FALCON MEADOWS AT BENT GRASS DRAINAGE CHANNEL

CONSTRUCTION DRAWINGS (PLAN & PROFILE)

CDR 21-14

HORIZONTAL CONTROL

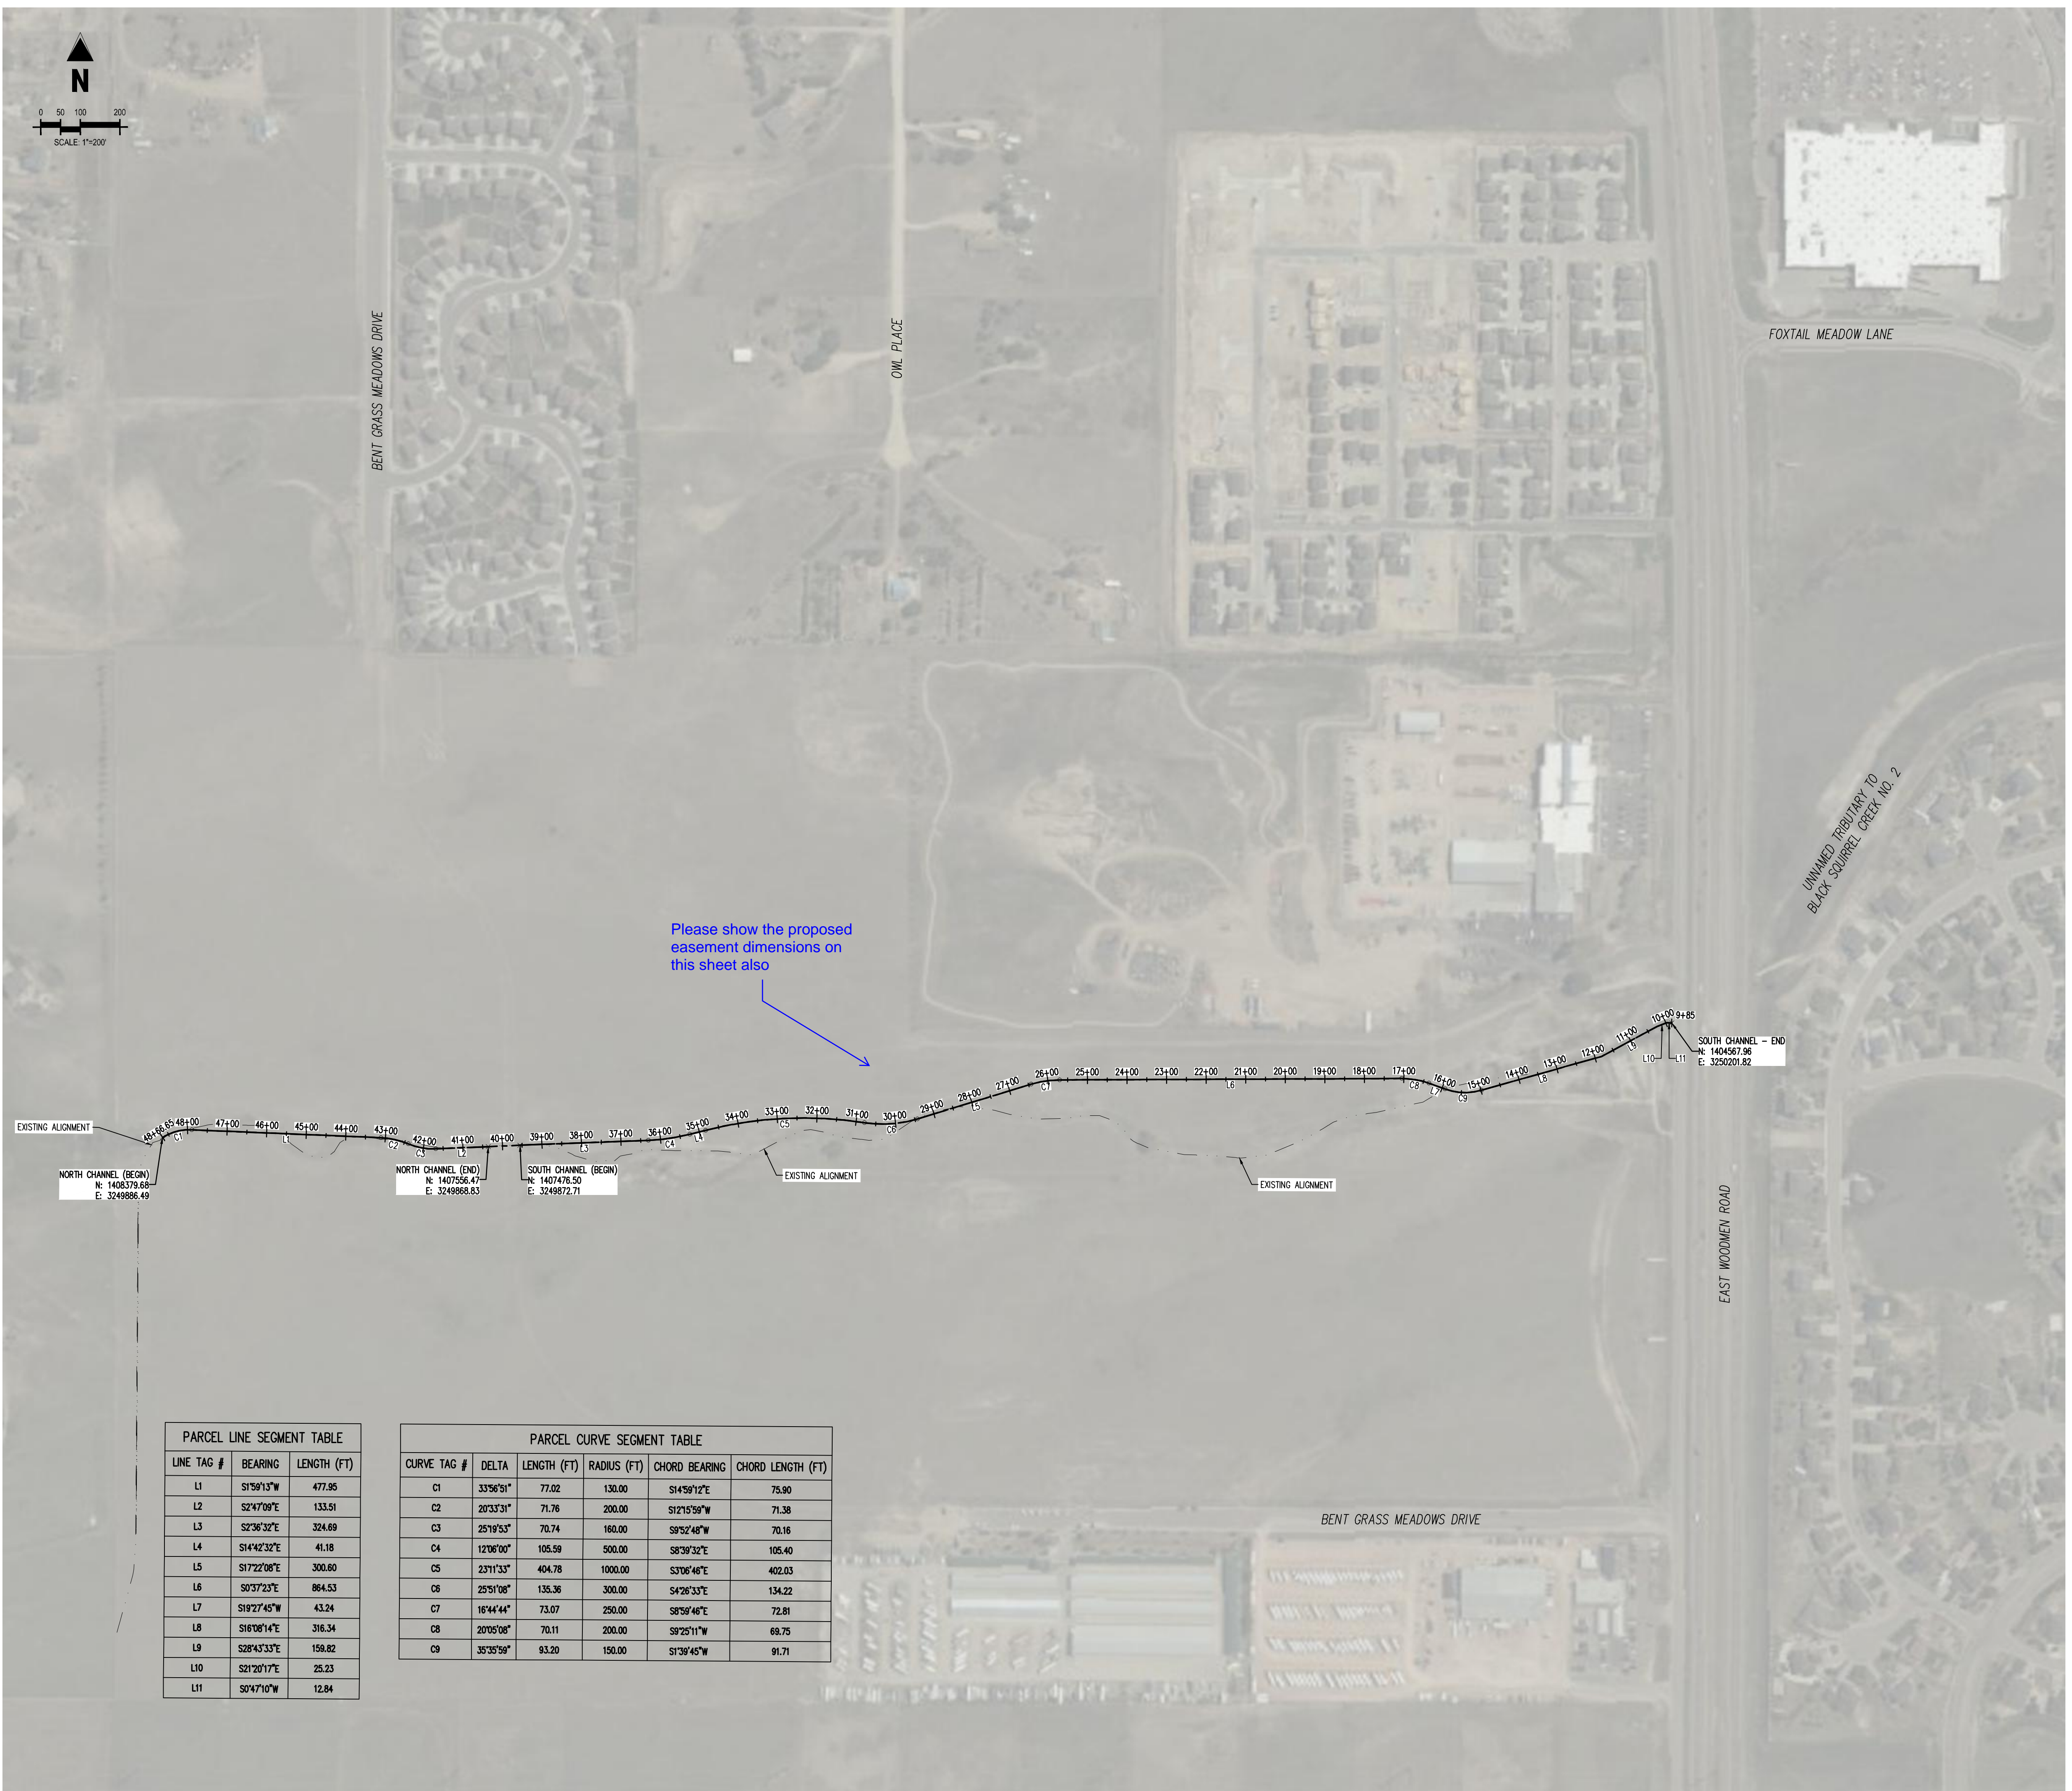
↑
Show and label
the existing
alignment also
